A38 Derby Junctions

8.66 Applicant's Responses to Information or Submissions Received by Deadline 4

**Applicant's Responses to Information or Submissions
Received by Deadline 4**

Regulation Number	Rule 8(1)(k)
Planning Inspectorate Scheme Reference	TR010022
Document Reference	TR010022/APP/8.66
Author	A38 Derby Junctions Project Team, Highways England

Viewpoint 24

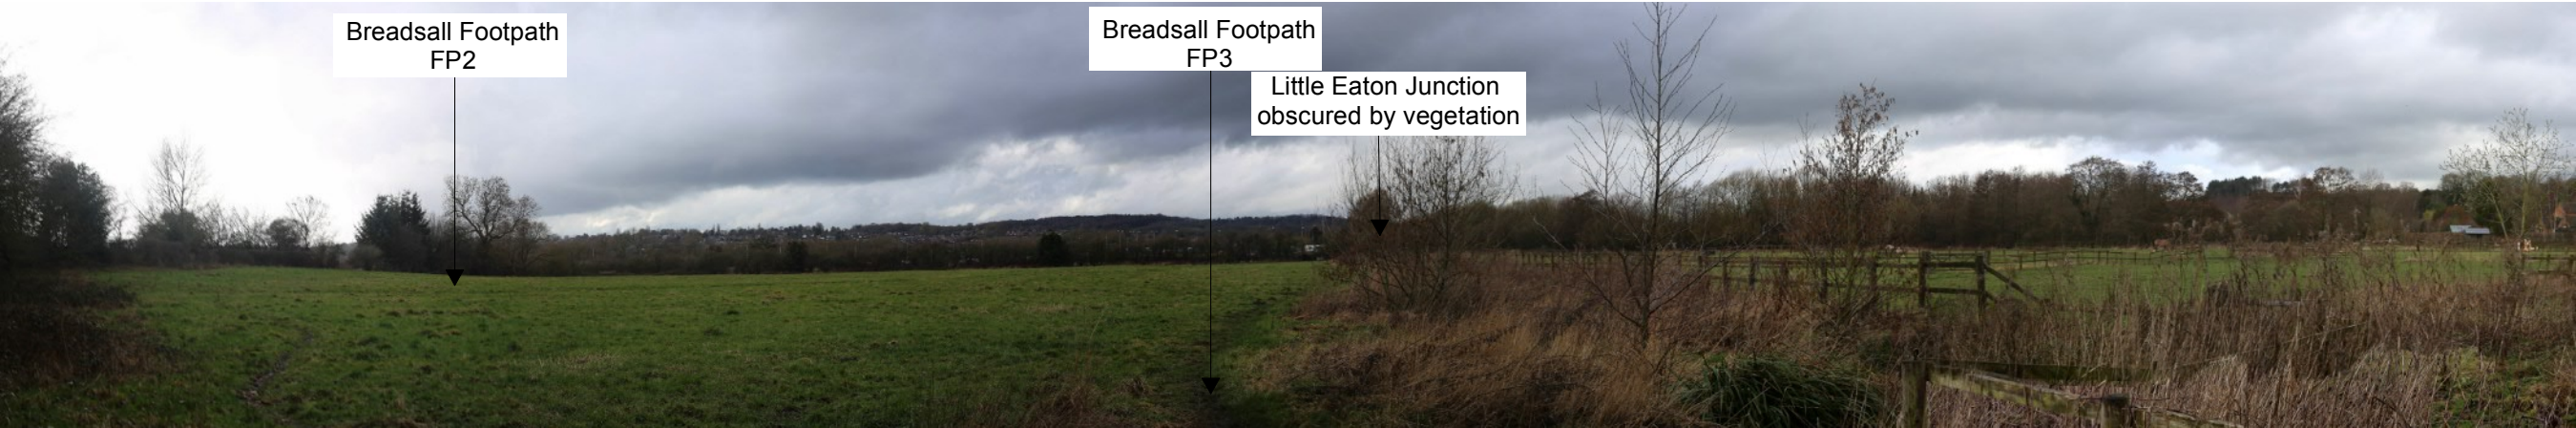
Ref	Source	Comments	Applicant's Response
		<p>photomontage (24) substantially repeats the earlier versions supplied by HE. It is assumed that the earlier photomontages still apply.</p> <p>As far as the Parish Council is concerned, therefore, nothing has changed. HE has essentially incorporated some mitigation measures but, as it admits, there will be some adverse effects on Breadsall Village and the green belt more generally, especially during the early years of the scheme. The key issue which appears to have dropped off the agenda is that</p> <p>a) there are alternative routes to the north west of the present junction which would use mainly brownfield and avoid almost all adverse effects on Breadsall and the quality and openness of the Green Belt.</p> <p>b) the process by which the Highways Agency and later Highways England rejected these alternatives was deeply flawed.</p> <p>The Parish Council addressed this issue in detail in its first written representation and remains of the view that the only equitable solution is to re-run the selection process for the design of the Little Eaton Junction. It is trusted that the Examining Authority will take full account</p>	<p><i>adjacent to Dam Brook at Little Eaton junction can be increased in width to provide further screening". As such, Highways England does not consider the ExA needs to impose any further requirement in this respect.</i></p> <p>It is noted that the photomontage taken in the middle of the village [Viewpoint 11 in REP3-018] was requested by Derby City Council to determine potential Scheme impacts on the views from All Saints' Church towards the Derwent Valley Mills World Heritage Site. The photomontages submitted during the Examination supersede those as submitted prior to DCO submission.</p> <p>Regarding the option selection for Little Eaton junction, Breadsall Parish Council has made the same points as were raised in their Relevant Representation (and repeated in their deadline 3 submission) and these were addressed in the Applicant's Deadline 1 submission [REP1-003] and have been discussed and explored subsequent to this at the hearings. As such, Highways England considers that this issue has been fully</p>
